**PROPERTY AT 119 PROSPECT ROAD AND 50-52 SEAVIEW STREET, SUMMER HILL
LANDSCAPING AMENDMENT FURTHER DETAILS SECTION 4.55(1A) MODIFICATION APPLICATION TO
AMEND SSD 10371
PART 4, DIVISION 4, ENVIRONMENTAL PLANNING AND ASSESSMENT REGULATION 2021**

Thank you for your recent correspondence in relation to the above modification in relation to the redevelopment of Trinity Grammar School. Modification 2 (MOD2) of **SSD-10371** seeks minor amendments to the landscaping scheme at the School pertinent to design changes, following design development and project coordination of the scheme.

The modification was lodged on 3 March 2022 and we received an initial request for information on 9 March 2022 from Jasmine Tranquille. We subsequently received a formal Request for Further Information (RFI) prepared by Gavin Ho on 8 April 2022 of which we were given until 9 May to respond. This letter is in response to this RFI.

01 PLAN
Oval 2 Car Park Level B1 Proposed
Scale 1:200

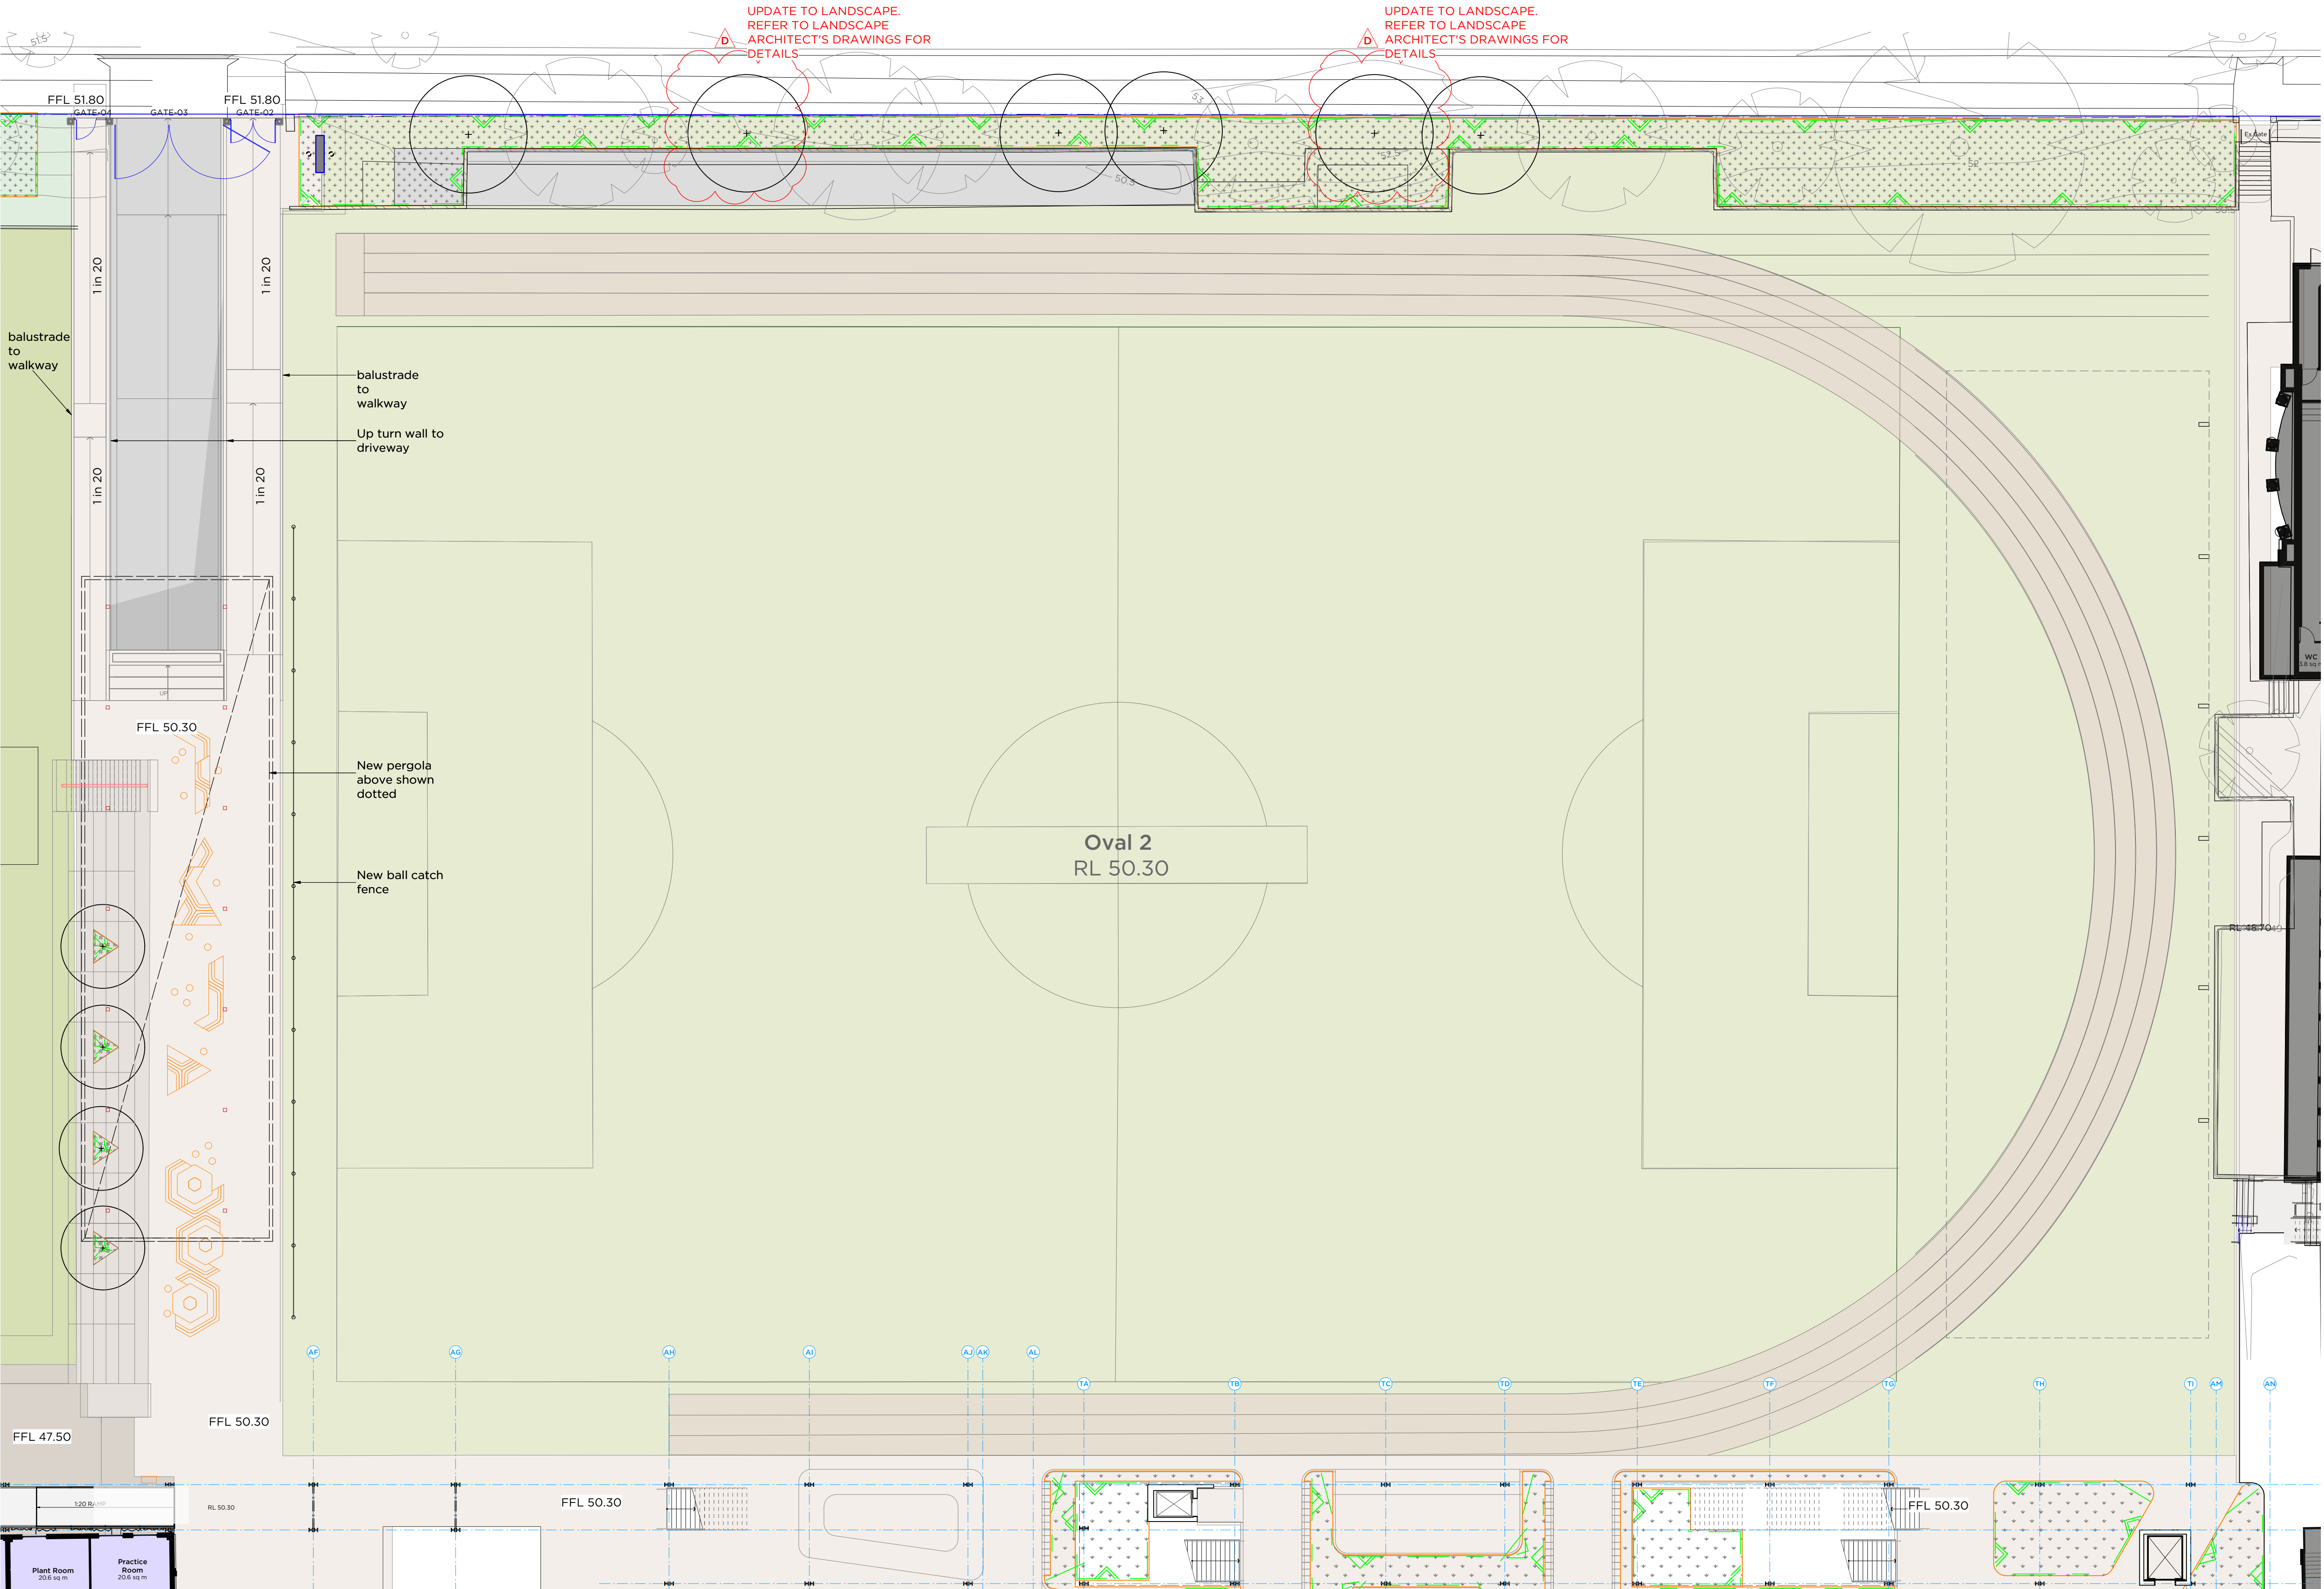
d) Spot levels

The updated drawing **2808 DA151 Proposed Oval 3 Car Park B1 E** contained within **Appendix D** shows additional surface RLs along the perimeter edge of Oval 3 at FFL 47.60 as per the modification proposal. The fall of the oval has now been updated and the proposed level, FFL 48.15 approximately at the centre of the Oval is shown.

To put this matter beyond doubt, no alterations or amendments are proposed to the level heights of Oval 3.

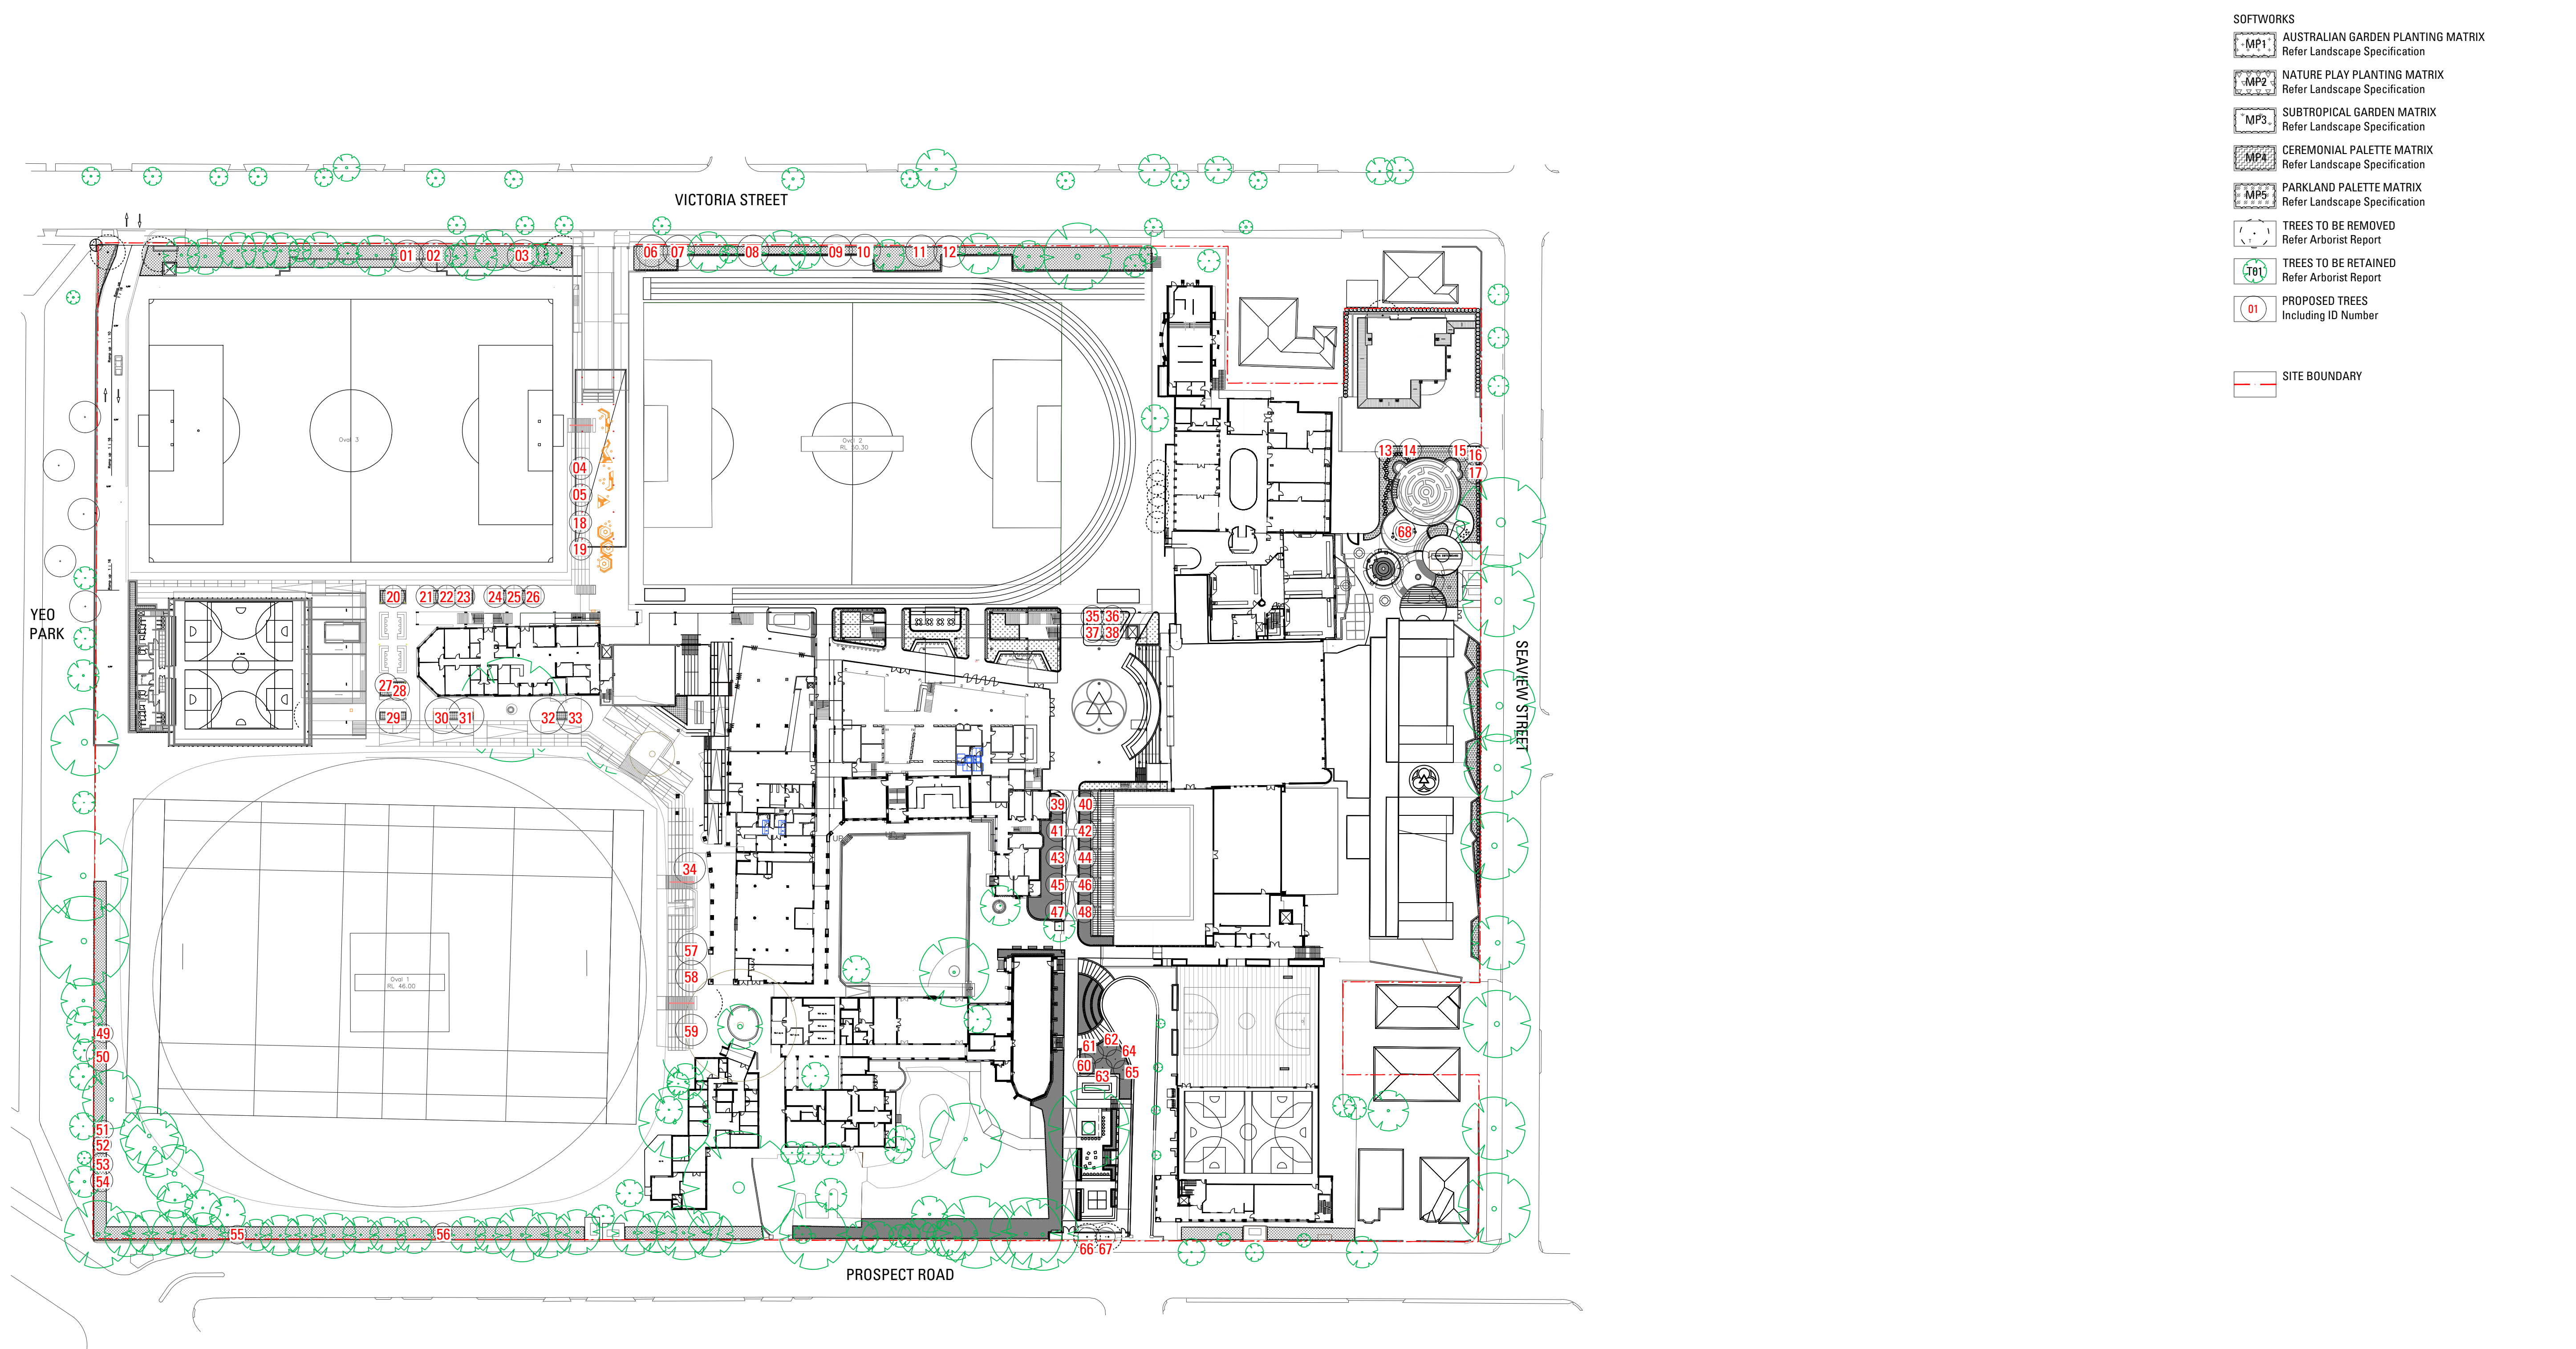
d) Tree Identification numbers

Sheet 100 has been updated to include the 68 proposed new trees in accordance with planning Condition A1(2)(iii).
